# CITY OF ALBUQUERQUE

April 24, 2025

**RE: 2500 Phoenix Ave. NE**  
**Menaul & Vasser**  
**Grading & Drainage Plan**  
**Engineer's Stamp Date: 01/03/2025**  
**Hydrology File: H16D156**  
**ABQ-PLAN File: HYDR-2025-00060**

MENAU AND VASSAR
 2500 PHOENIX AVE NE, ALBUQUERQUE,
 NM, 87107
GRADING AND DRAINAGE PLAN

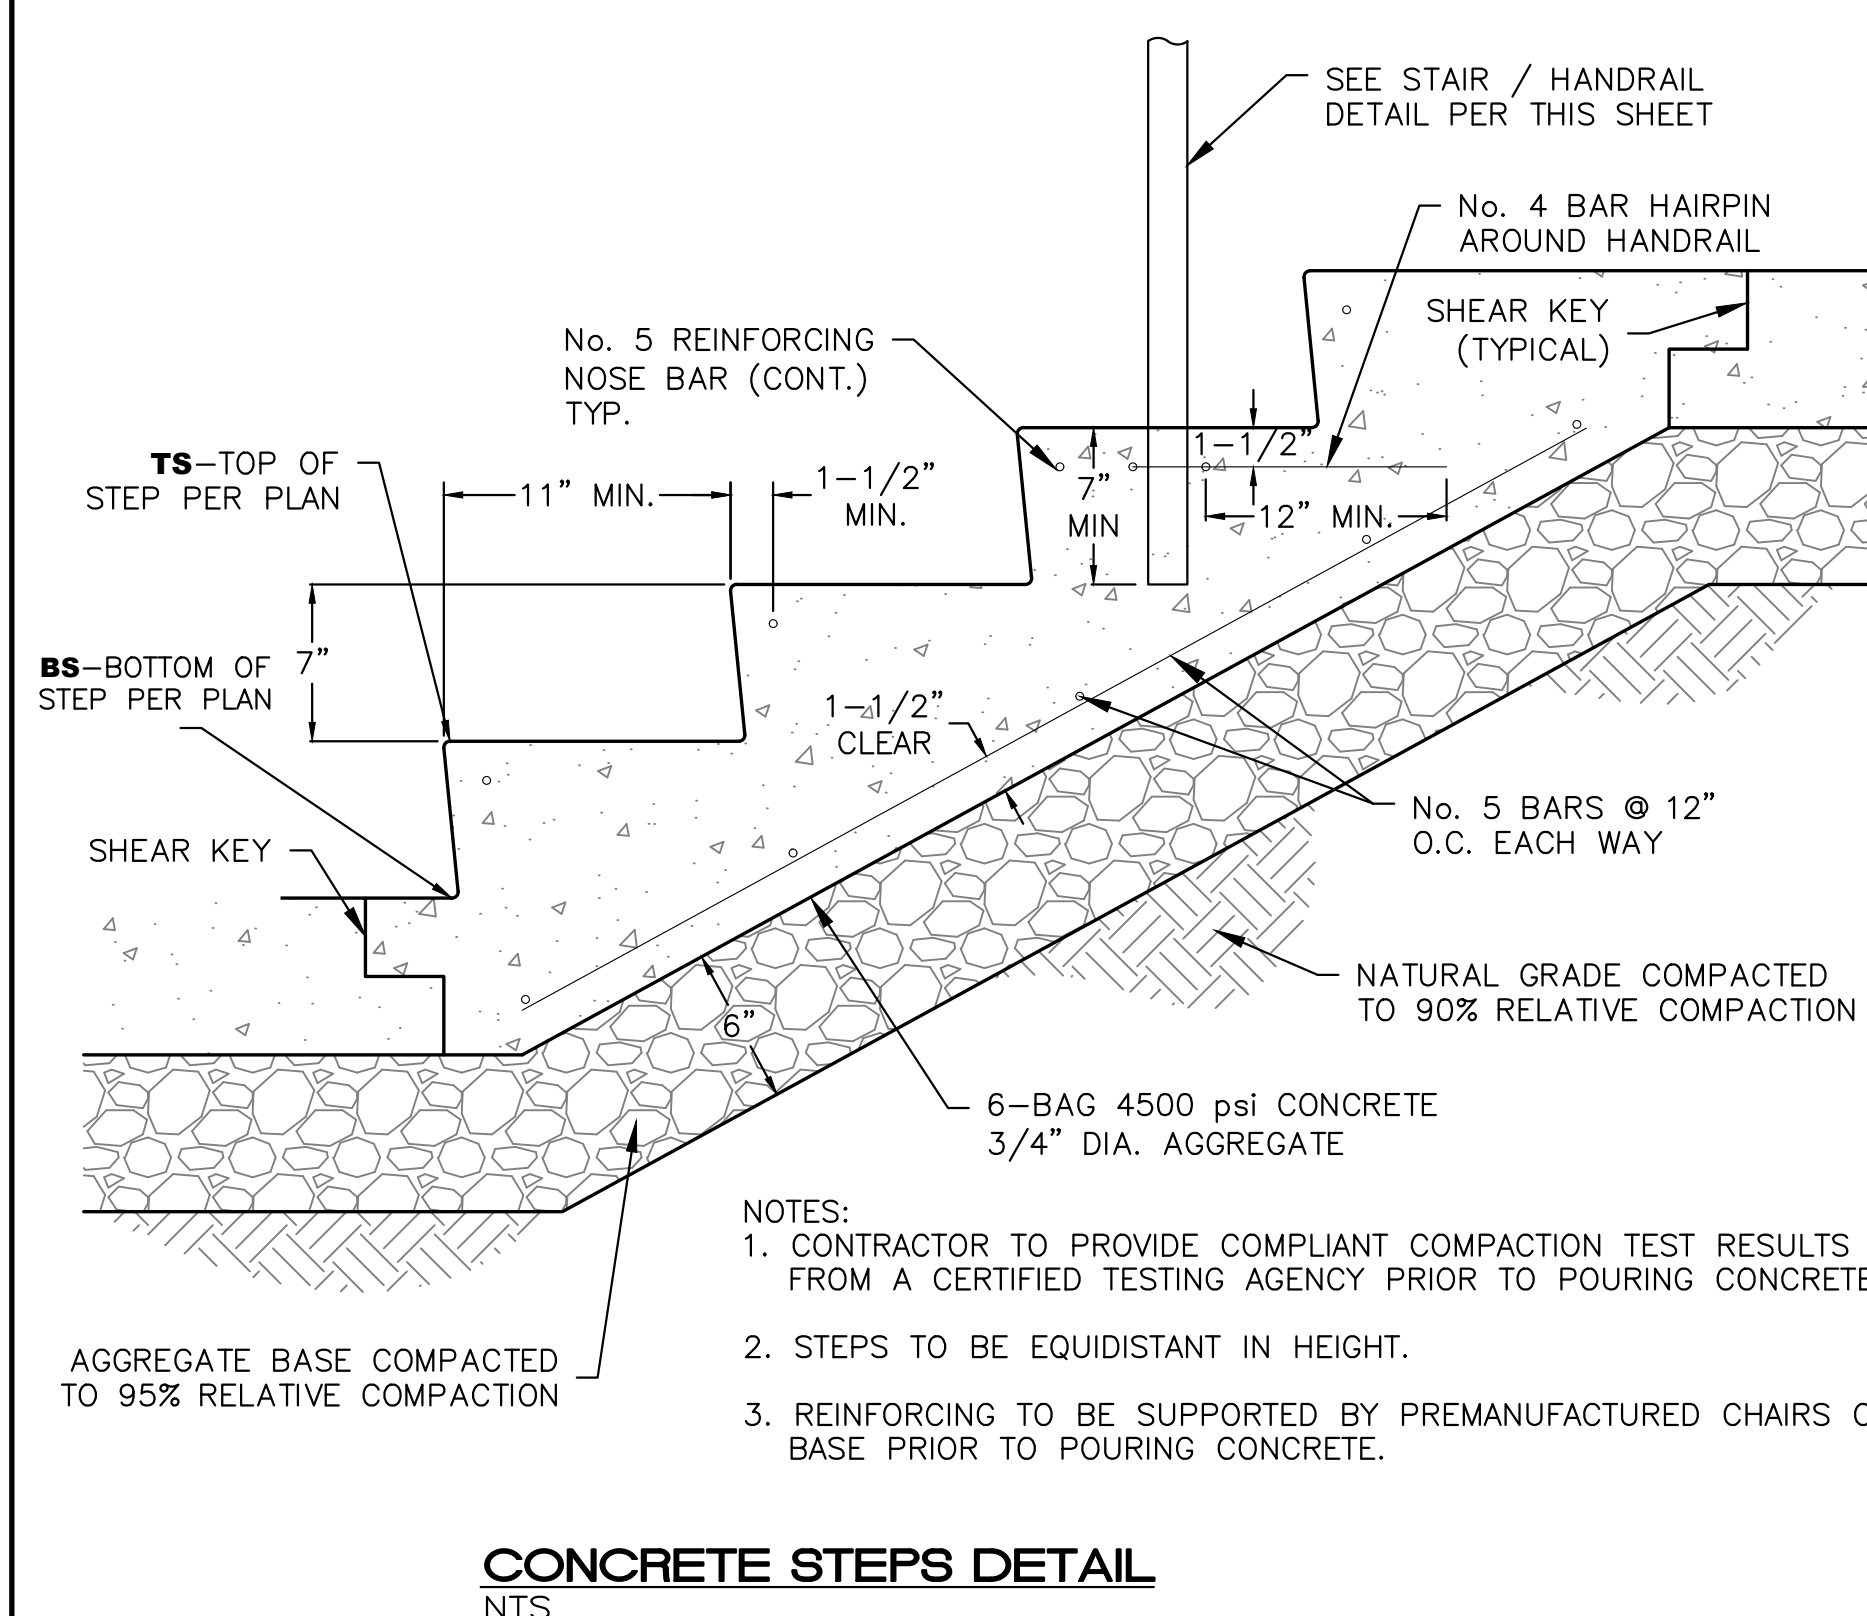
1. Revisions to Grading & Drainage Plans (G&D Plans) require a **current** Engineer's stamp and date. Revisions and corrections were made to the G&D Plans per the response letter dated April 2, 2025, yet the Engineer's stamp date is still 01/03/2025, and not acceptable.
2. From previous Comment No. 8 (CABQ Hydrology review of 03/11/2025): Sheet C2.0: From field observations, the existing 30' Private Access and Drainage Easement appears to be providing access to the property/parcel/business to the east of this project which would be adversely affected by the proposed retaining wall, both for vehicular access and stormwater conveyance.

**Response:** The access for Tract 1-D (the property/parcel/business in question) will divert to entering/exiting from Tract 2 (east of the property/parcel/business in question). This is shown on the grading plan with the callout "Future driveway." The owner for Tract 2 has agreed to the proposed driveway.

Please provide a copy of the agreement from the owner of Tract 2, with acknowledgment of the stormwater impacts to property if drainage easement to the west is vacated or abandoned.

EXISTING BASIN MAP

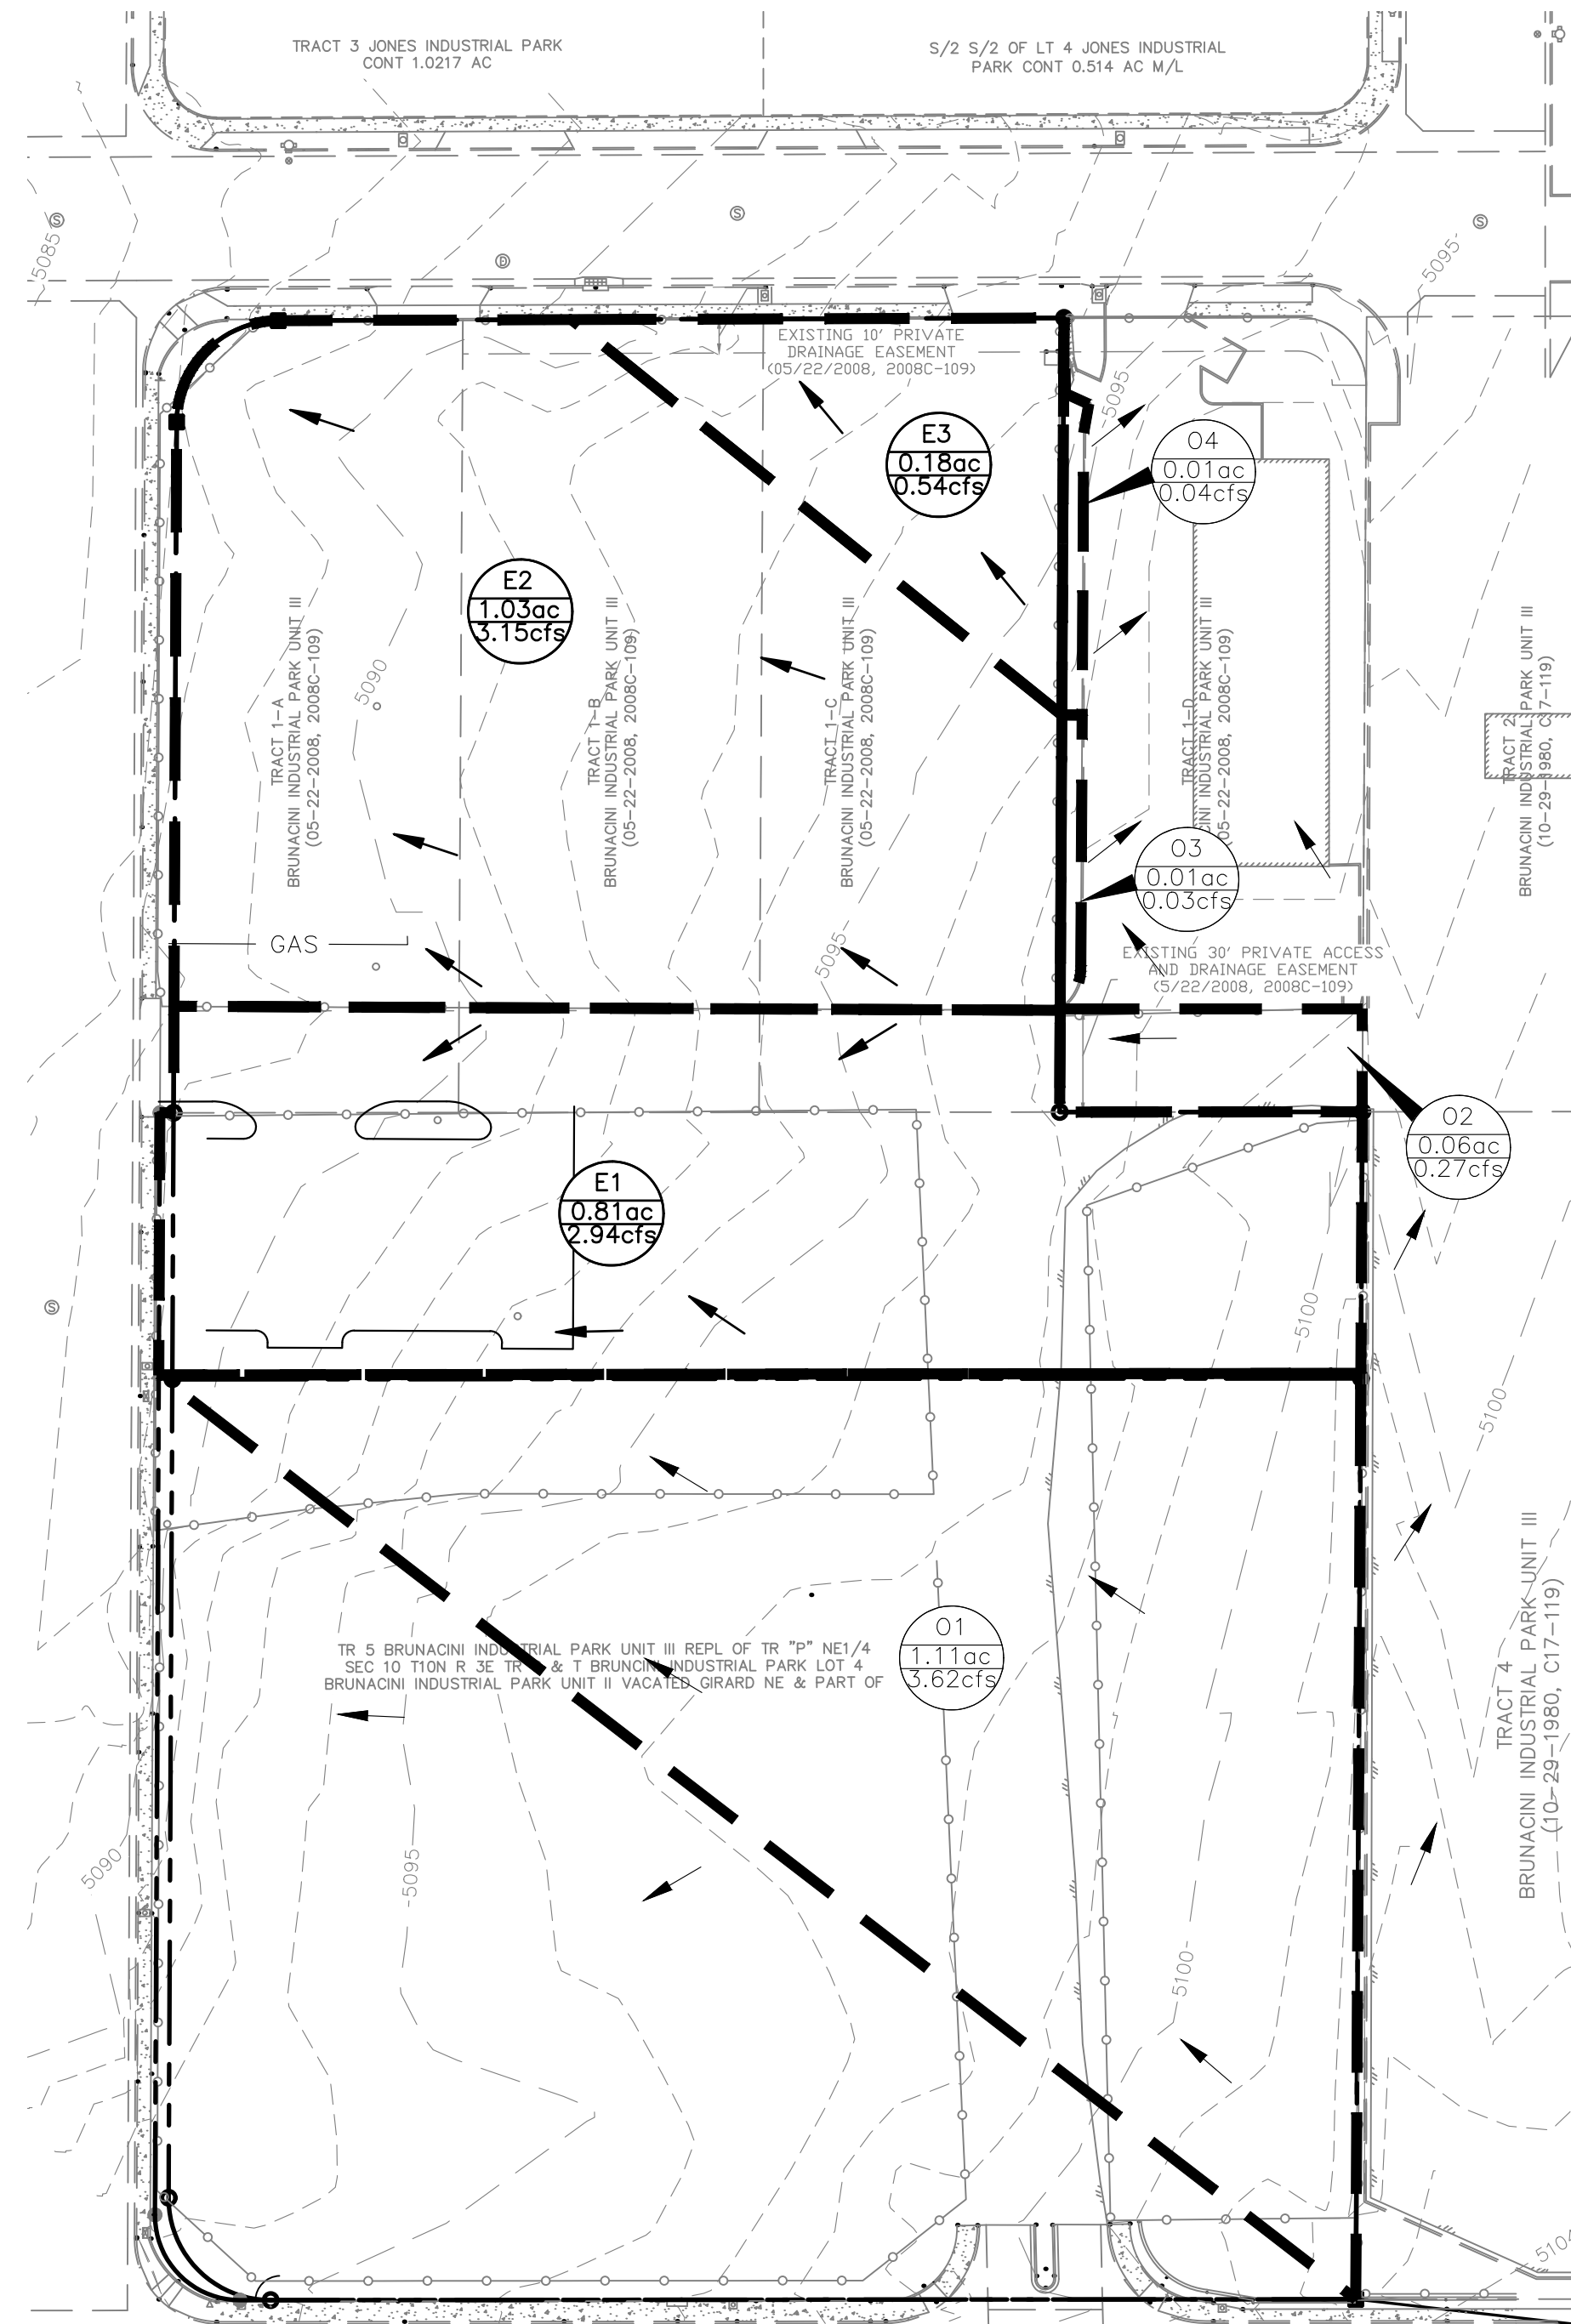
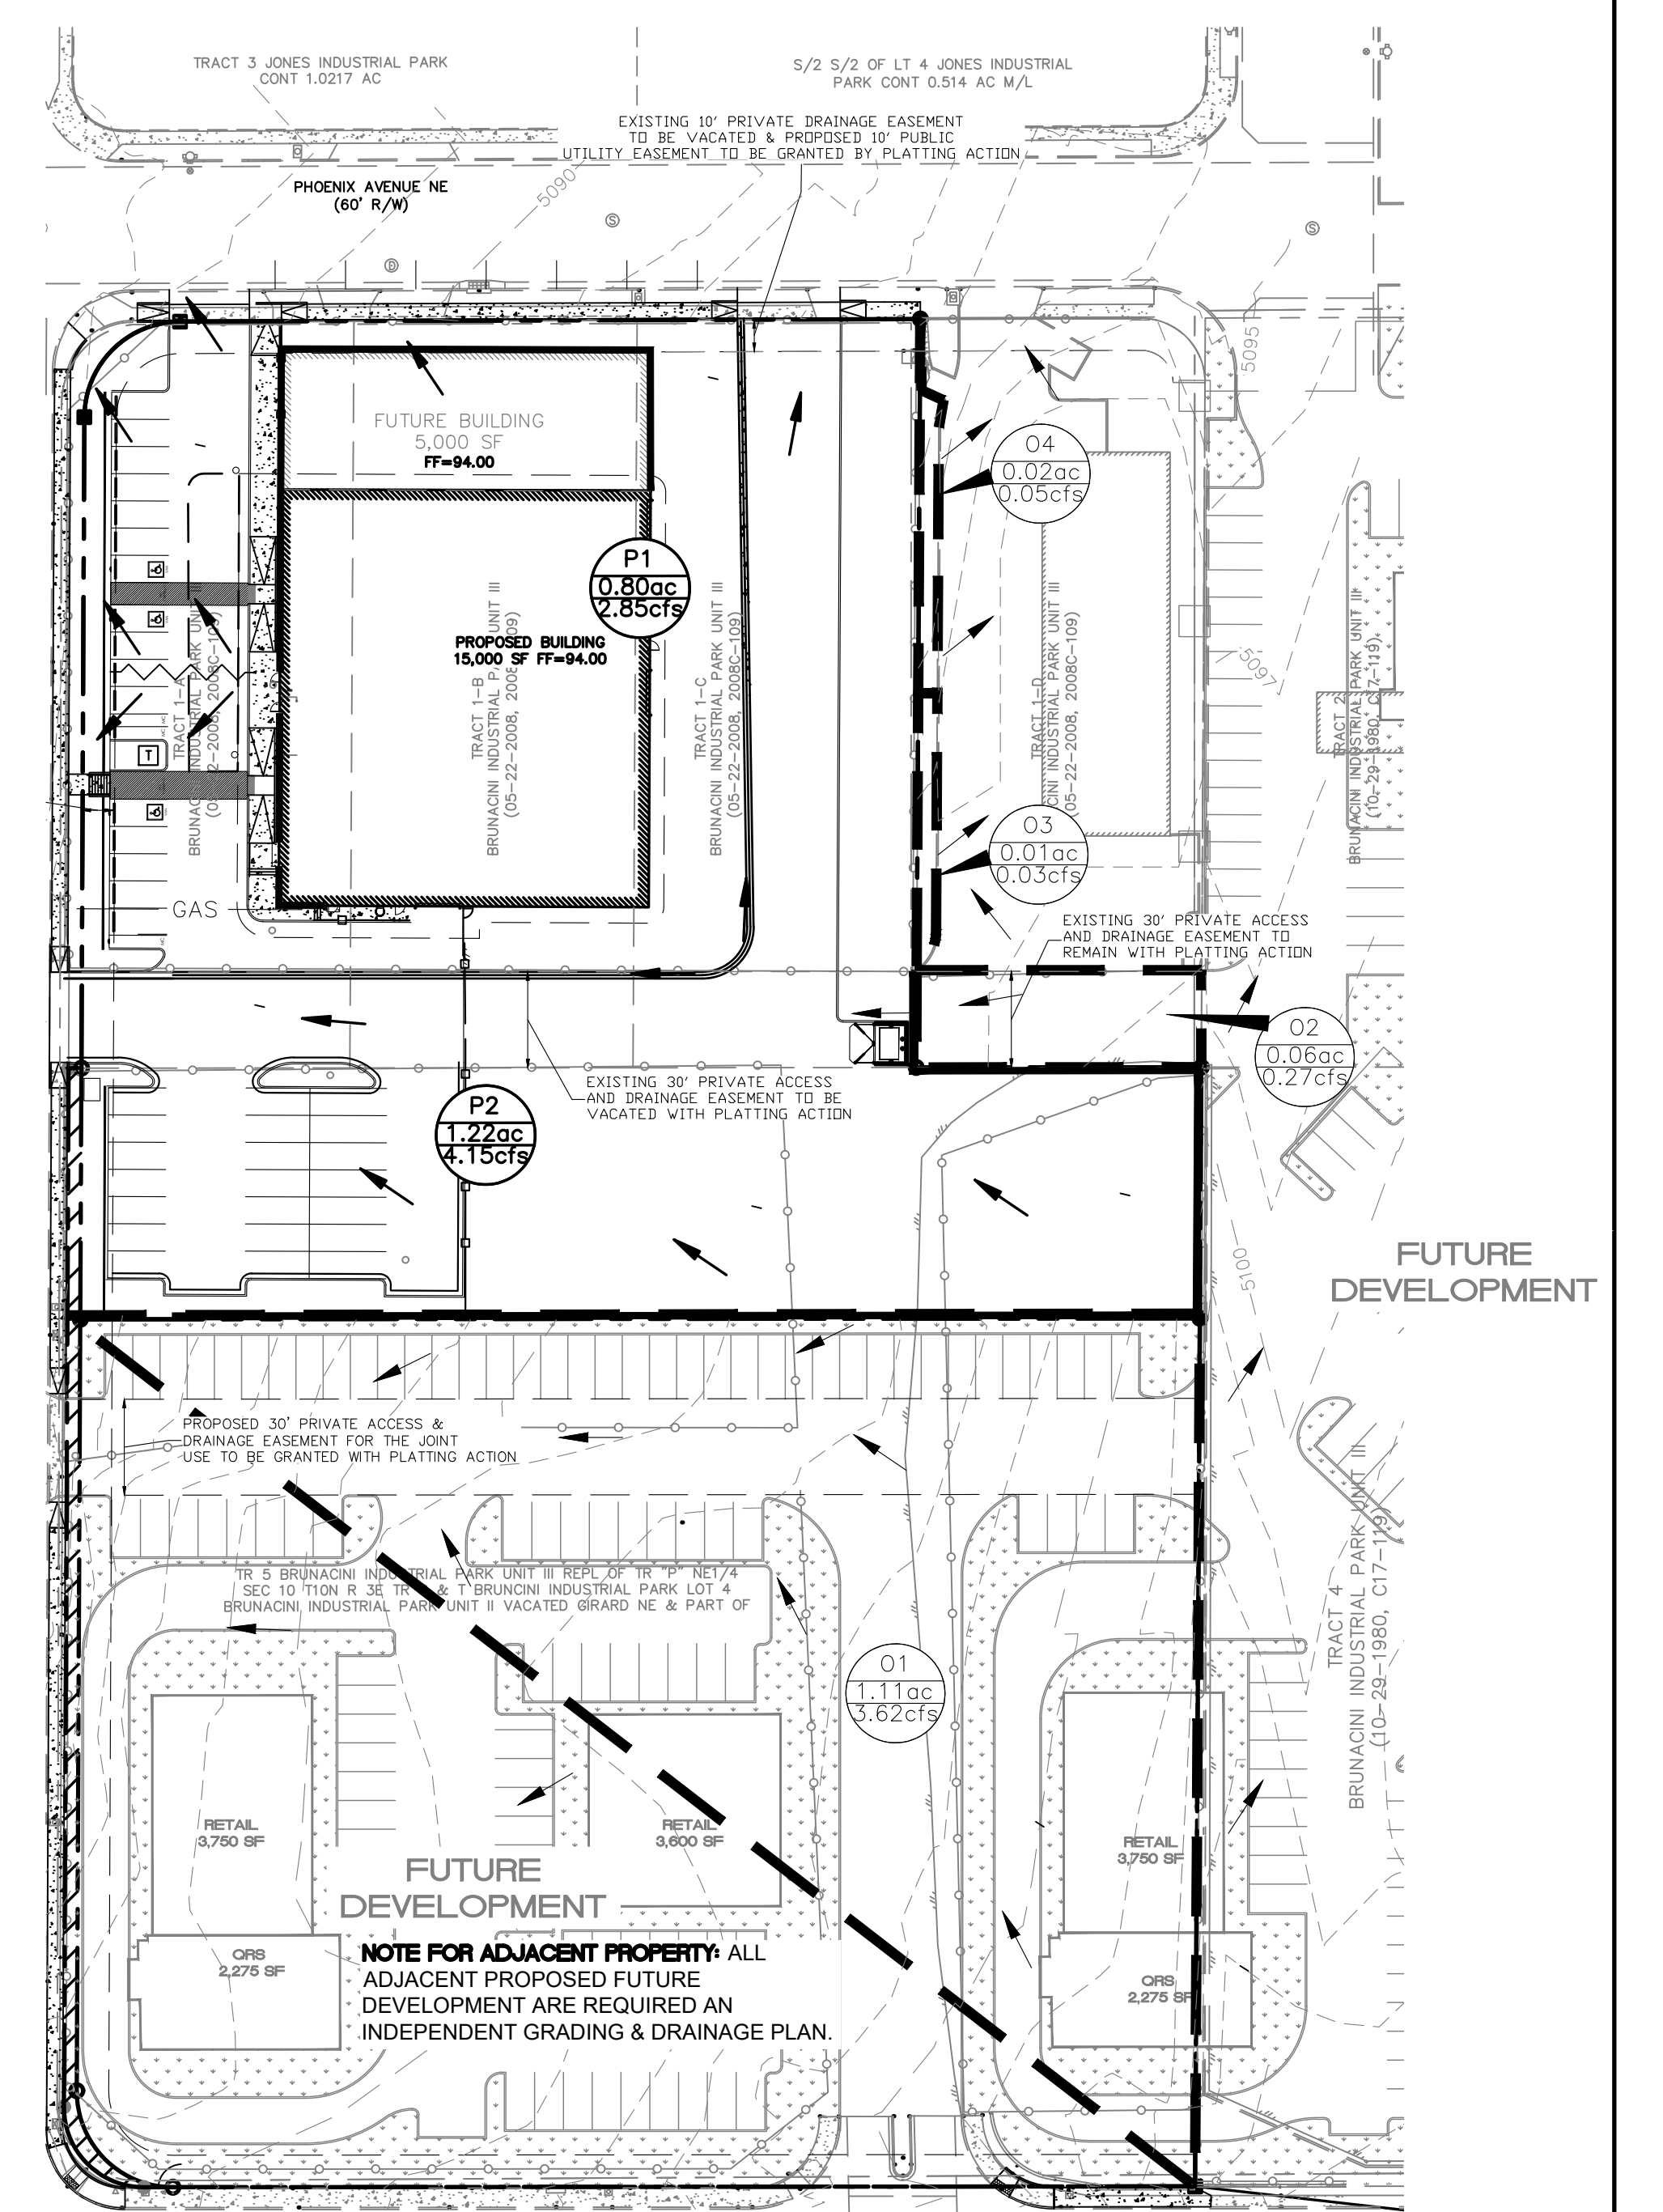
3. Additional plan sheets are referenced on the submitted G&D Plans and should be included in the re-submittal package.
4. The Waiver Application provided in this submittal states as justification that there is an existing 22-ft of fall from the southwest to the northwest which is not correct, thus the Waiver Application is not approved.
